Von Rief German Sheppard's, PPR-17-060

Please accept the following comments from El Paso County Public Health regarding the proposed kennel referenced above:

Proposed Layout
(site plan)

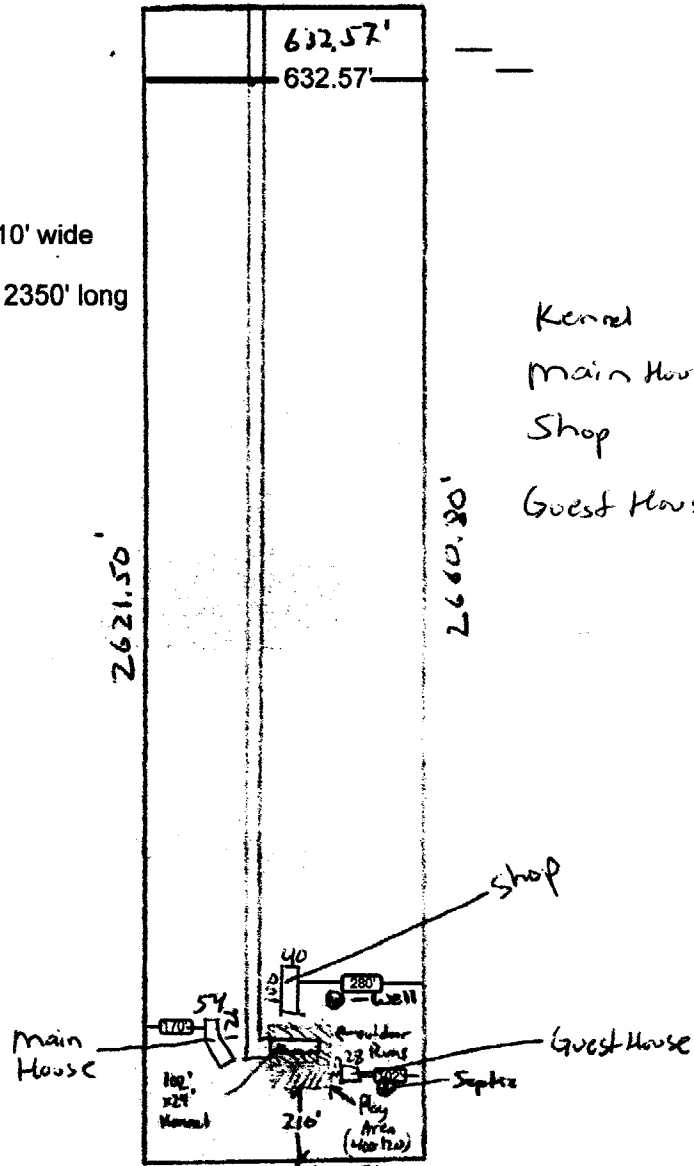
- **The on-site wastewater treatment system (OWTS) for this proposed commercial kennel must be designed by a Colorado Registered Professional Engineer, and approved and permitted by El Paso County Public Health (EPCPH). Please make sure that components of the OWTS (including both the primary and secondary soil treatment area sites) are protected from vehicular traffic and other means of compaction.**
- **El Paso County Public Health recommends storing animal food in impervious containers with tight fitting lids in an effort to minimize rodent and insect attraction.**
- **Dog waste should be managed properly to help control nuisance odors, minimize flies and other insects. The proposed waste disposal plan is acceptable.**
